EXHIBITION OF ENVIRONMENTAL ASSESSMENT FOR NUNDAH BANK THIRD TRACK (MP 10_0094)

NUNDAH BANK THIRD TRACK PROJECT (MP 10 0094) - OEH COMMENTS ON EXHIBITED EA

Vegetation Communities and Hollow Bearing Trees Figure 7.2D

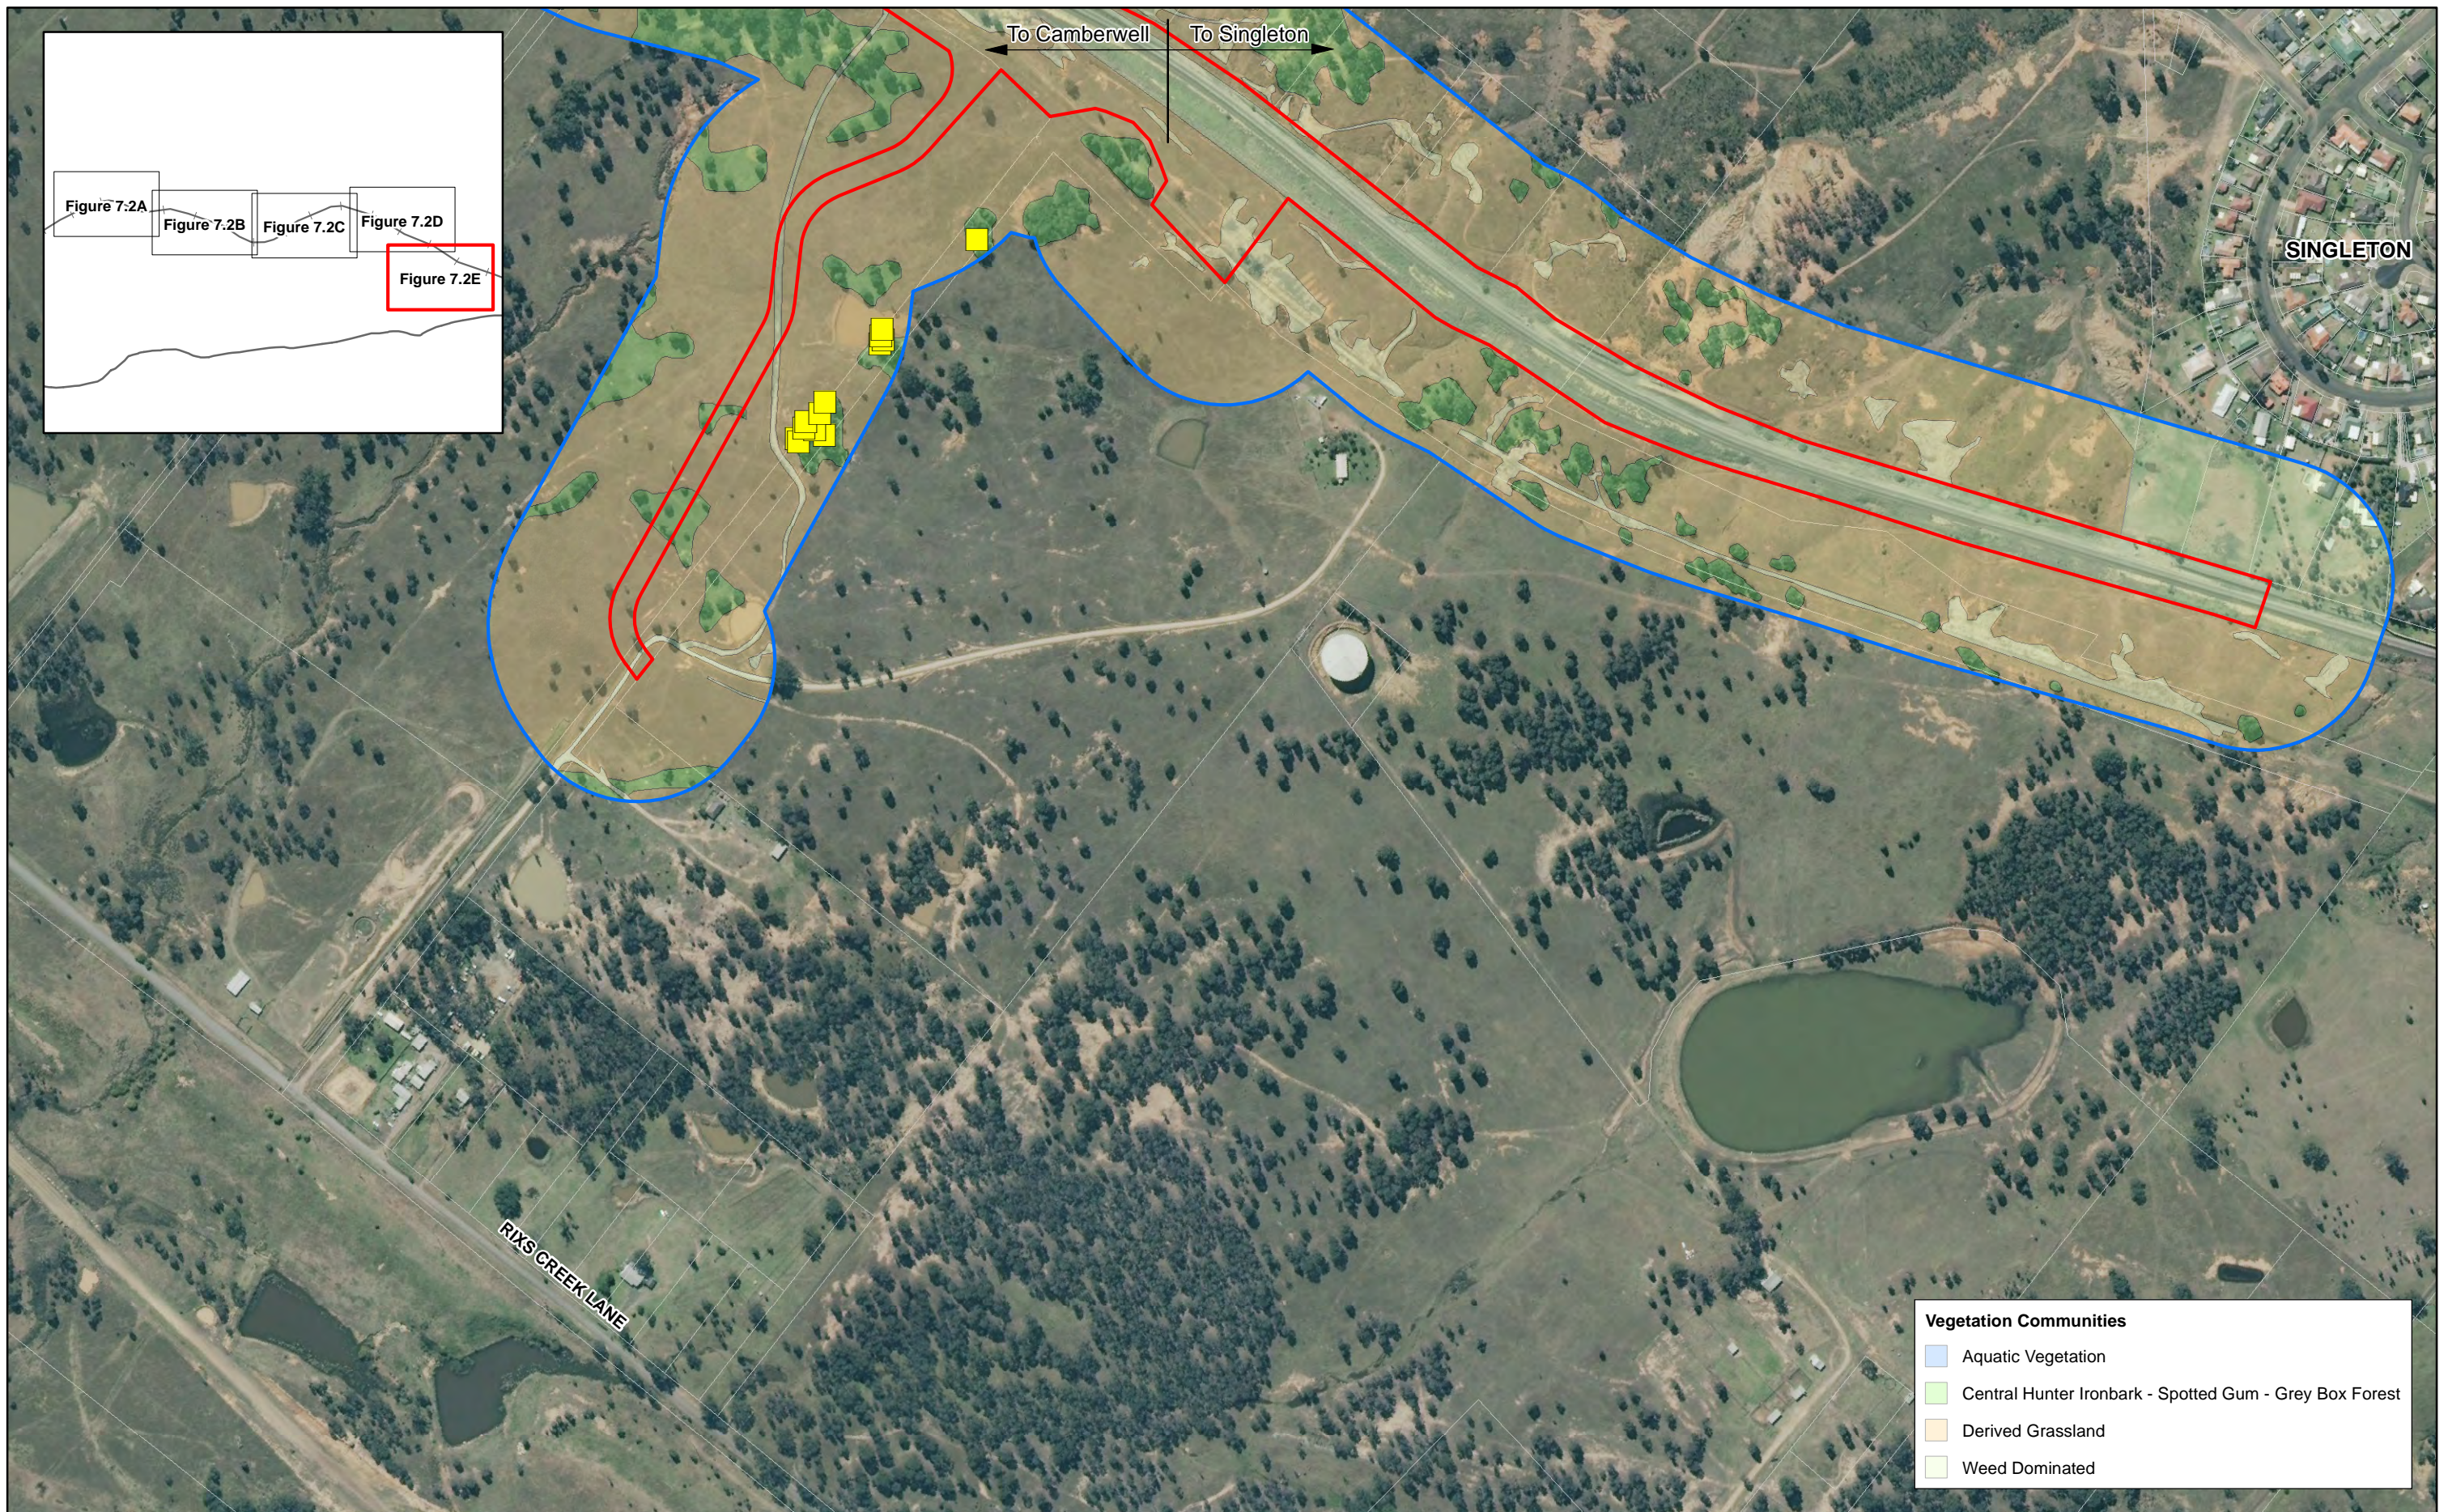
Section 5.2 (pg. 49) of the Ecology report, has a reference to an area of Swamp Oak Forest (0.12 ha) affected by the proposal which appears to occur near the northern limit of the project area (Figure 3A). However, this vegetation community is not described in section 3.2 of the Ecology report nor does its conservation significance appear to have been evaluated. OEH considers this may represent 'Swamp Oak floodplain forest of the NSW North Coast, Sydney Basin and South East Corner Bioregions' endangered ecological community (EEC). OEH notes that in Table 4.1 this EEC was not considered to occur in the study area. In the absence of details about the 'Swamp Oak' mapped on site it is not clear to OEH whether or not this vegetation type matches the EEC criteria in the final determination (NSW Scientific Committee 2004). As such OEH recommends that the proponent provide further details of the Swamp Oak Forest on site (particularly floristic composition, vegetation structure, an indication of the frequency and

duration of waterlogging at the site, and an indication of the salinity of the groundwater), and if any of the 0.12 ha to be affected by the proposal is EEC vegetation, and if so must be offset.
